From: Laura Gibbons <Laura.Gibbons@arun.gov.uk>
Sent: 01 June 2021 12:55
To: Planning.Responses <Planning.Responses@arun.gov.uk>
Cc: Michael Eastham <Michael.Eastham@arun.gov.uk>
Subject: RE: Planning Consultation on: WA/93/20/PL

Further Surface Water Drainage/ Land Drainage Comments

Application No: WA/93/20/PL
Registered: 30th March 2021
Site Address: Land East of Tye Lane Walberton BN18 0LU
Grid Reference: 497404 106234
Category: Plan Applicat'n
Description of Works: Alternative vehicular access off Tye Lane & emergency access off Avisford Park Road, along with minor highway works following WA/95/18/RES. This site is in CIL Zone 2 (Zero Rated) as other development.

Drawing Title:
**PROPOSED ACCESS IMPROVEMENTS
- TYE LANE/AVISFORD PARK ROAD**

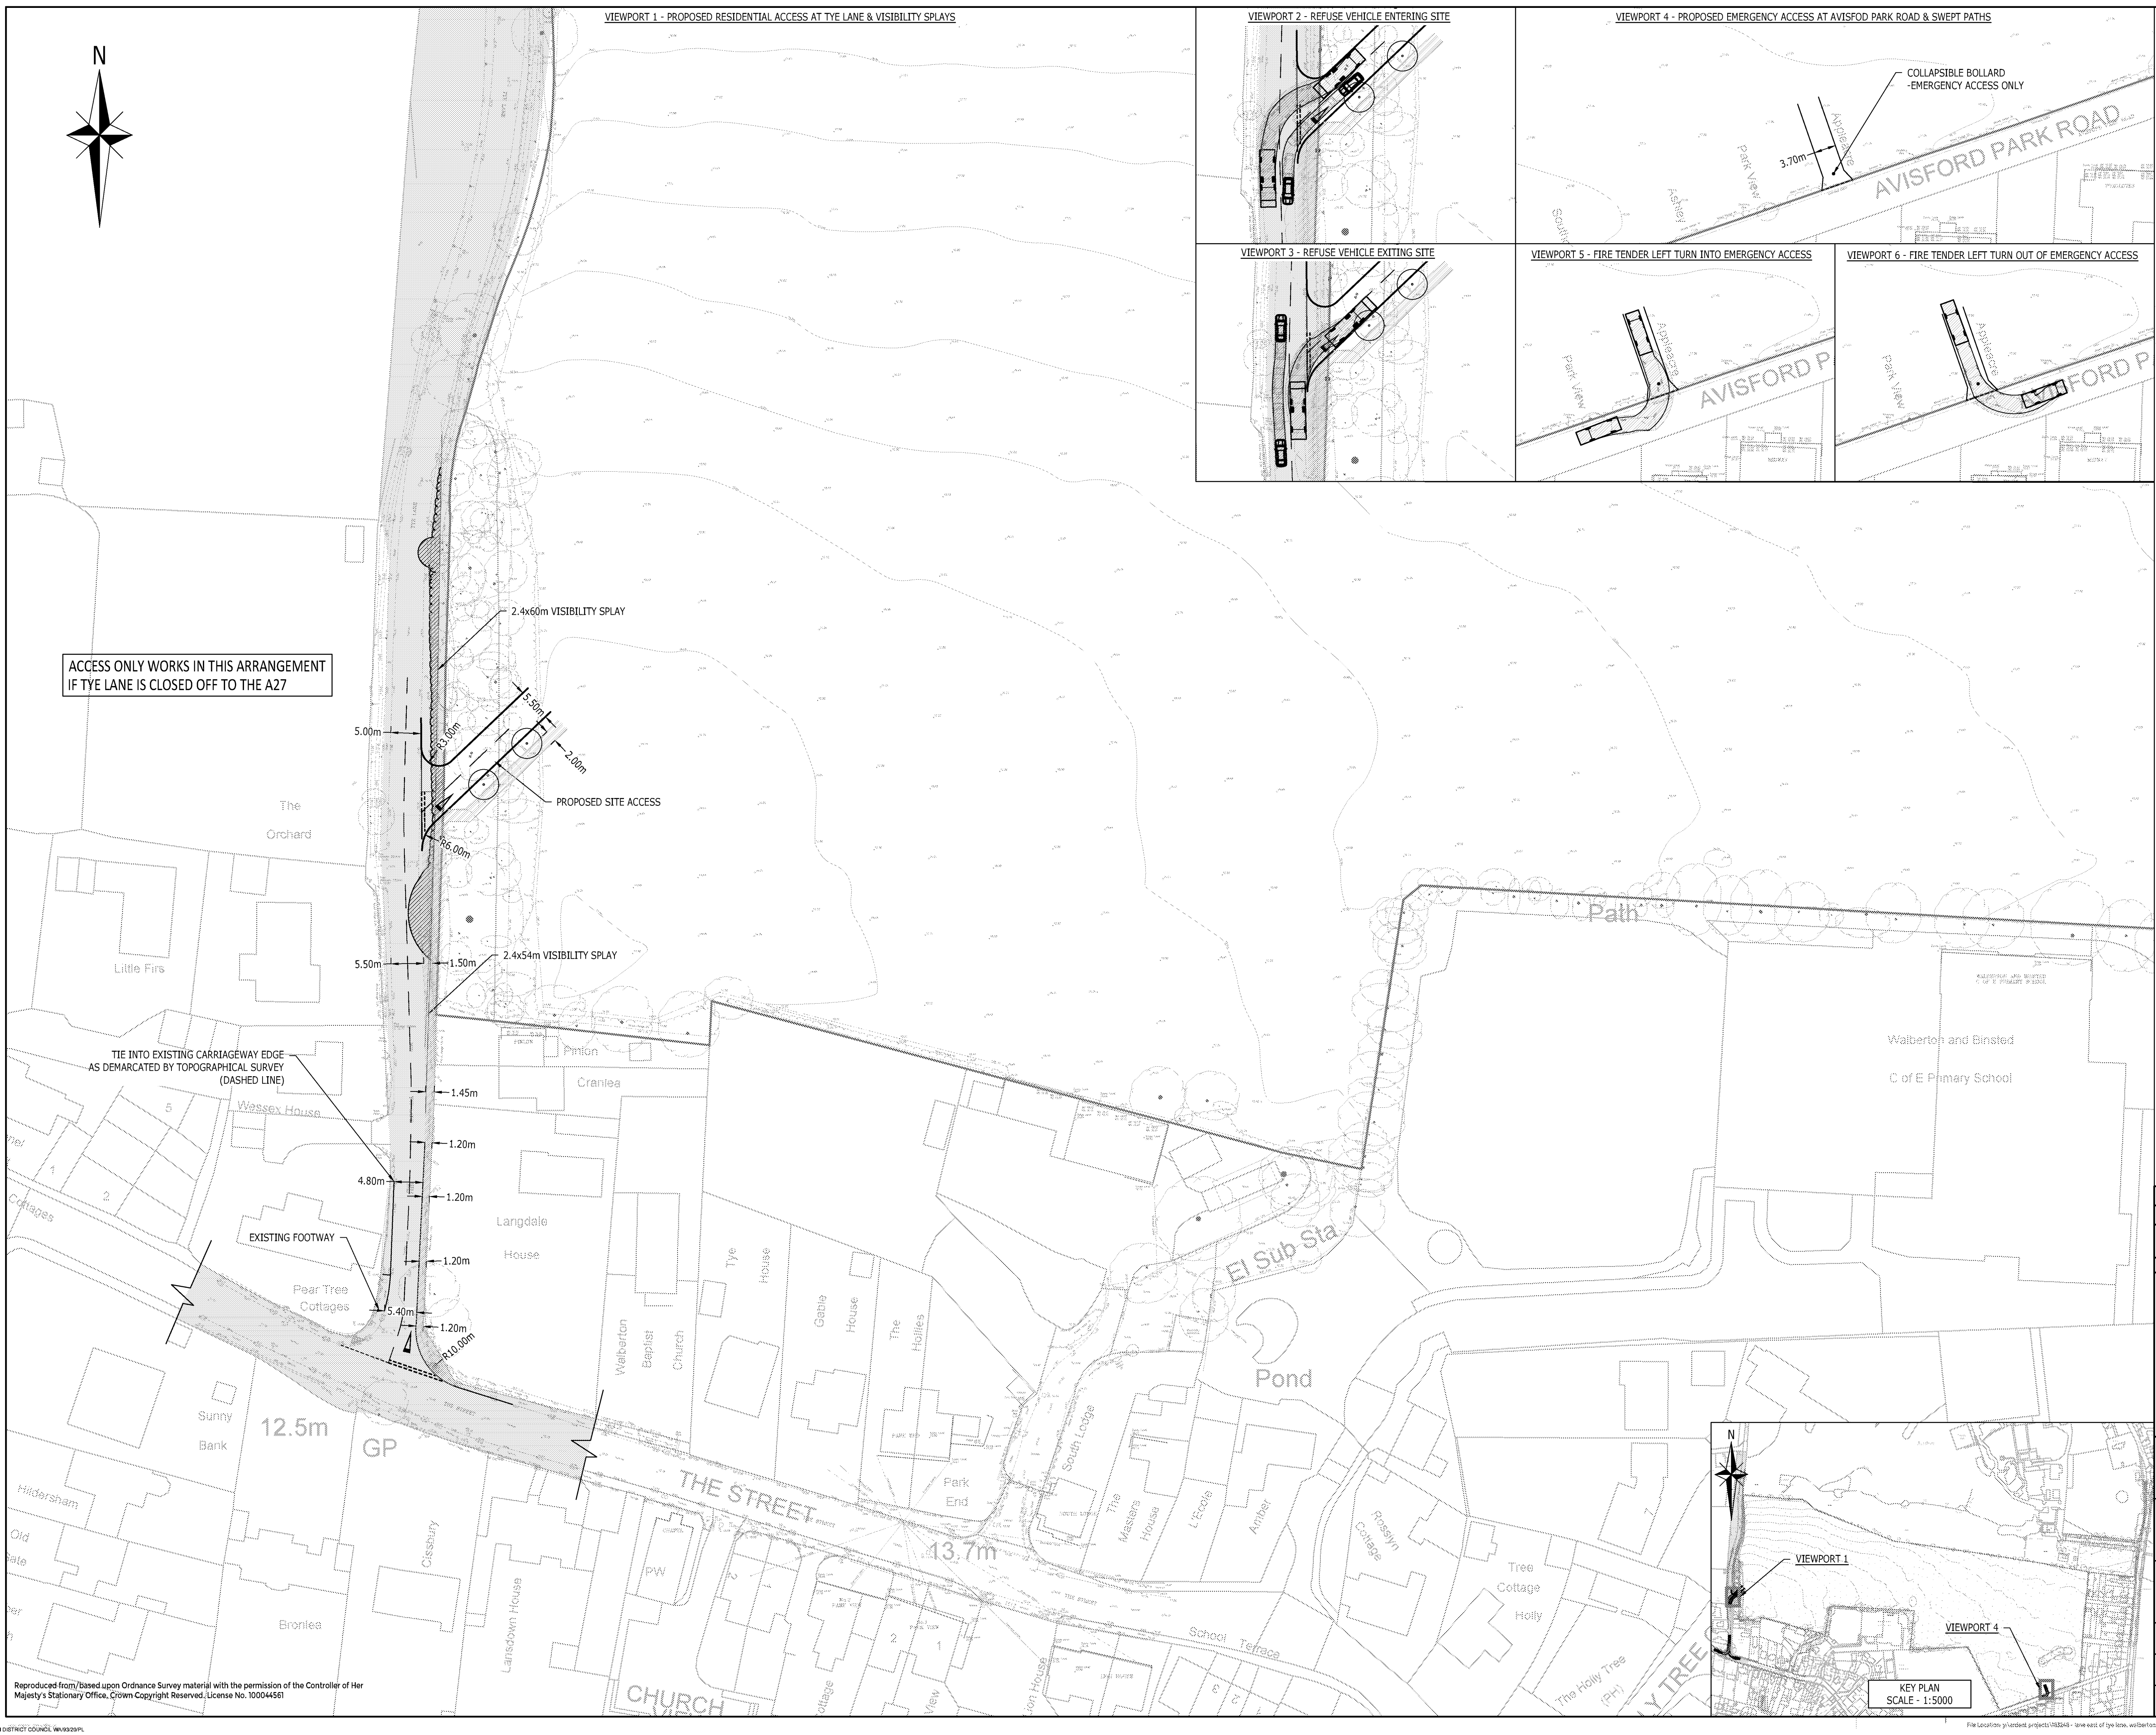
We maintain our holding objection at this time. No further specific details on the proposals for the revised watercourse crossing or the roadside ditch have been provided. It appears from the arboricultural statement and drawings that the ditch is to be infilled, yet no specific information on this as per our previous consultation has been supplied.

As per WSCC policy culverting and infilling of watercourses is not supported.

Please can the applicant submit a statement and details specific to the proposals for the watercourse.
